Application M/56/15/HH
31 Sea Way, Middleton-On-Sea, West Sussex, PO22 7RZ

We are writing to object to the revised proposals. We welcome the omission of the freestanding garage to the front of property, however we are still of the opinion the remaining proposal are a gross over development of the site which will effect our enjoyment and amenity of our property. The proposals are also clearly contrary to the Middleton on Sea Village Design Statement, specifically the *Future Development Guidelines* which states;

Proposed Elevations  
Sections B-B  
C-C  
D-D

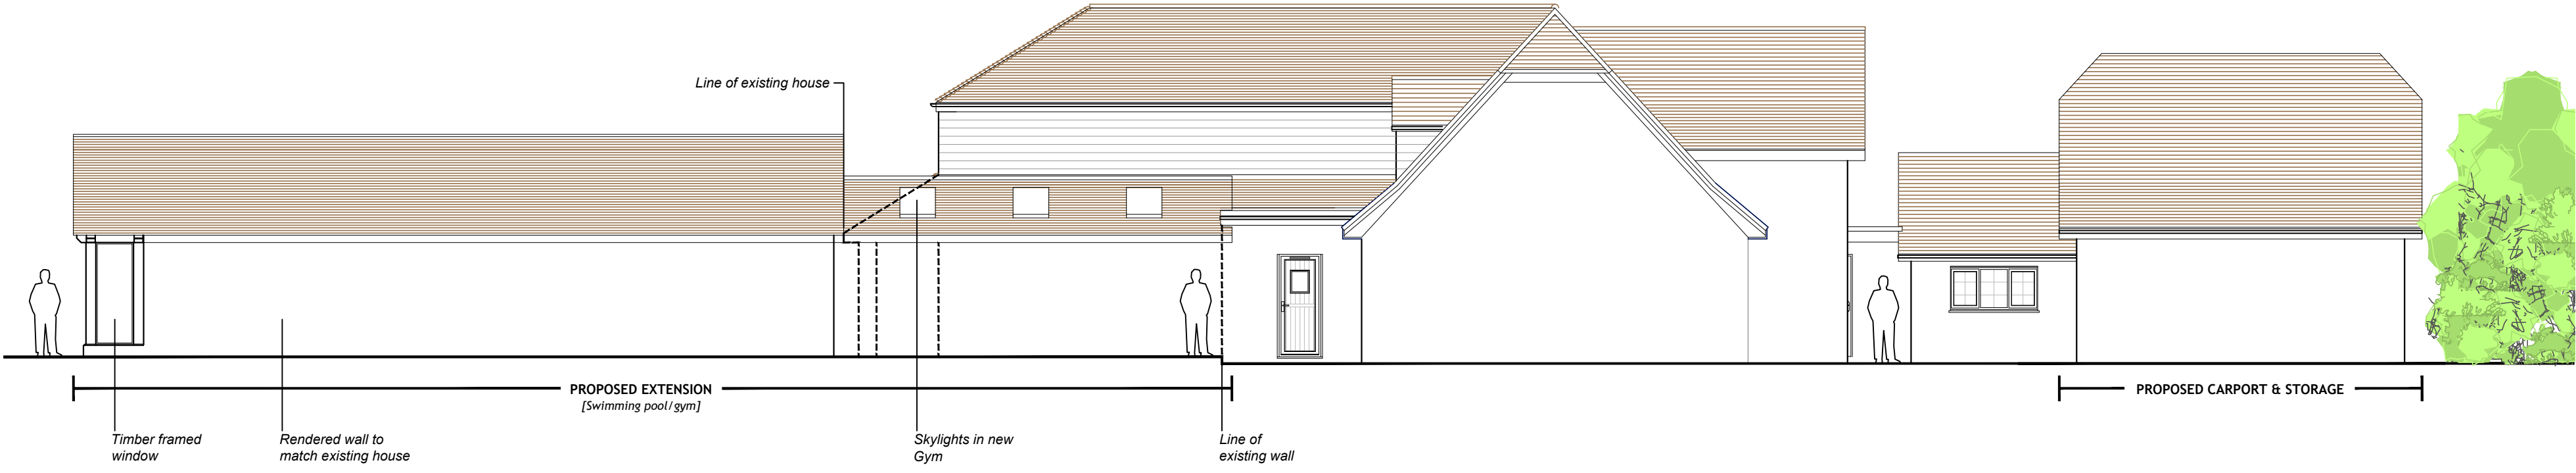
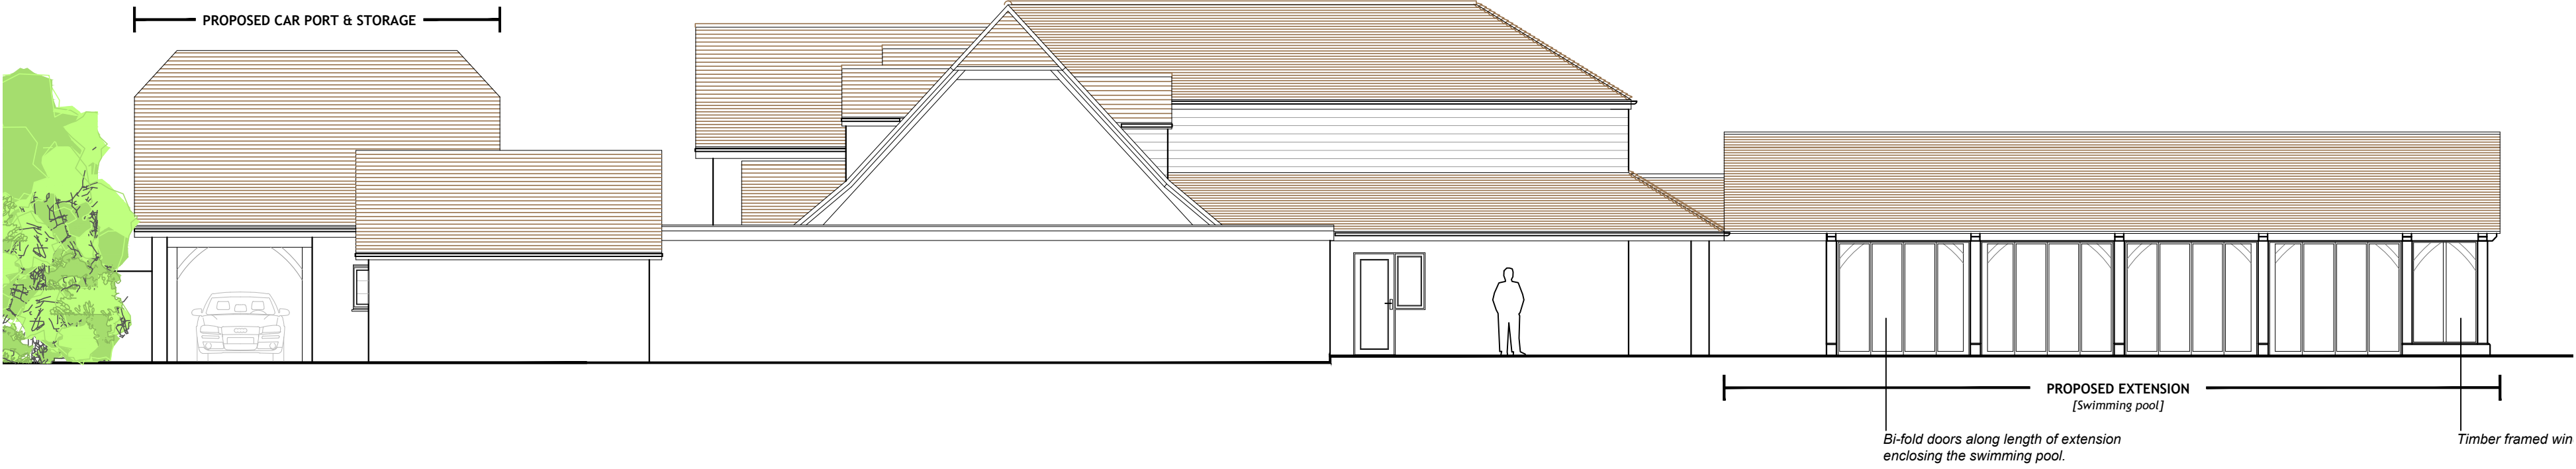
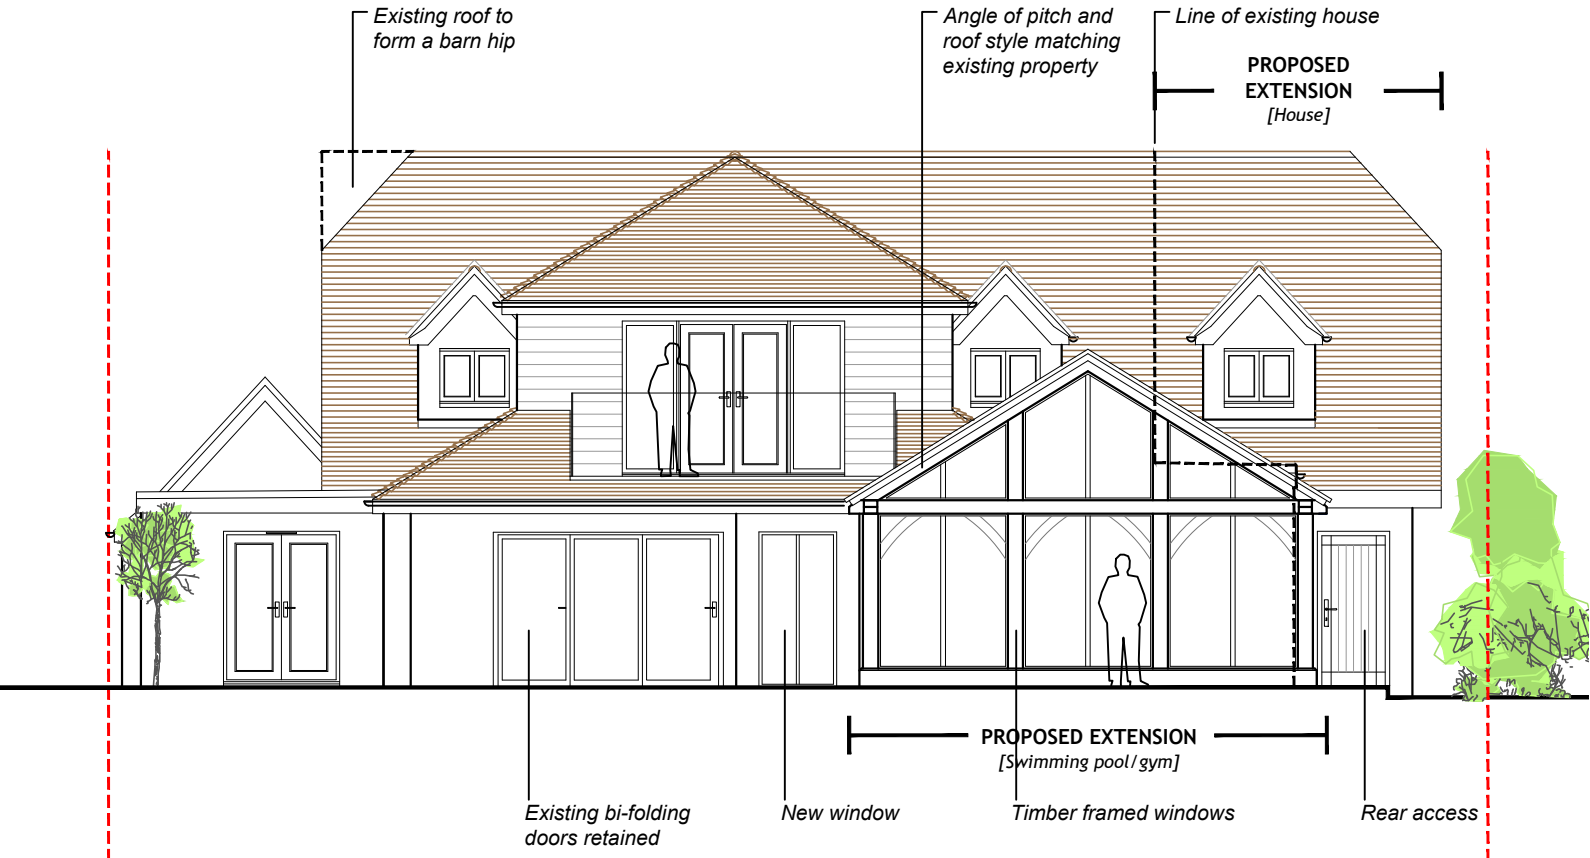
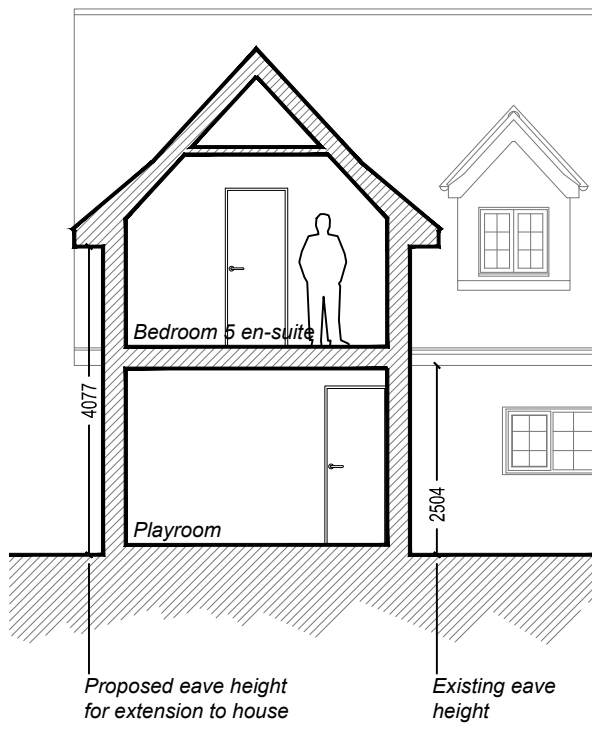
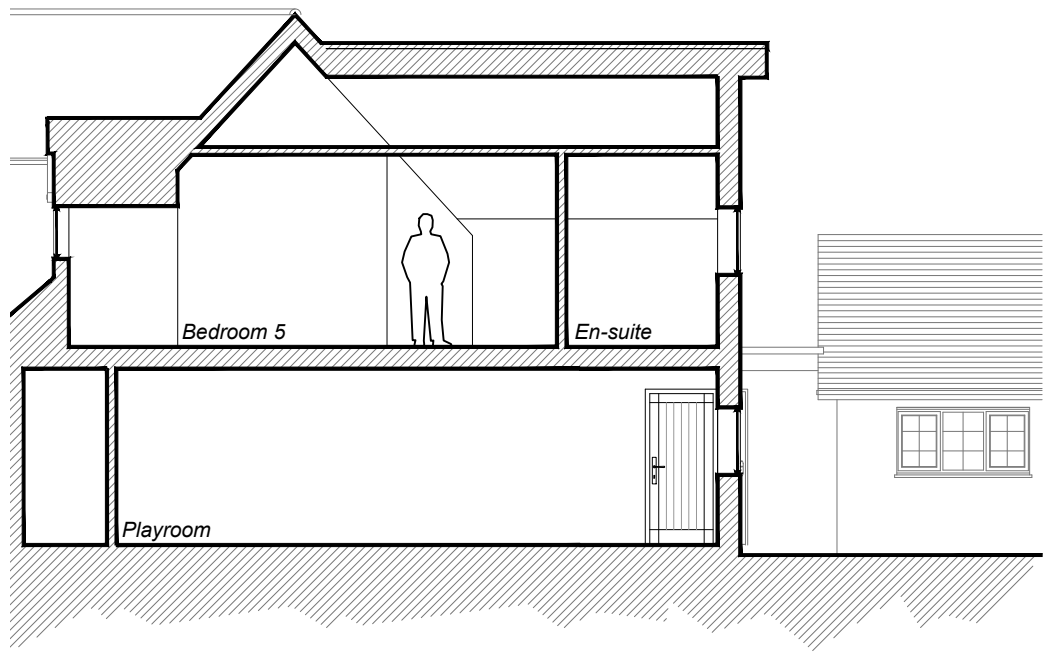
The revised plans for proposed swimming pool extension has reduced the ridge height by **480mm** to approximately **4.00m** high but the length at **15.5m** has not changed and it is still extremely high and long and very bulky. If approved, 36m of my west boundary will have a structure built up against it, this equates to approximately 50% of the linear boundary. For a detached house on an "open plot" this is a considerable loss of western sunlight. Looking from our first floor the 15.5m of pool roof will be the main feature, not the sea!

Should the hedge between the two properties, that is claimed to form a visual screen, survive the construction process it is only 3m tall and will not really obscure the 15.5 x 6m bulk of the pool.

No attempt has also been made to omit the window on the south east corner of the pool which will look directly into our garden again affect our privacy.
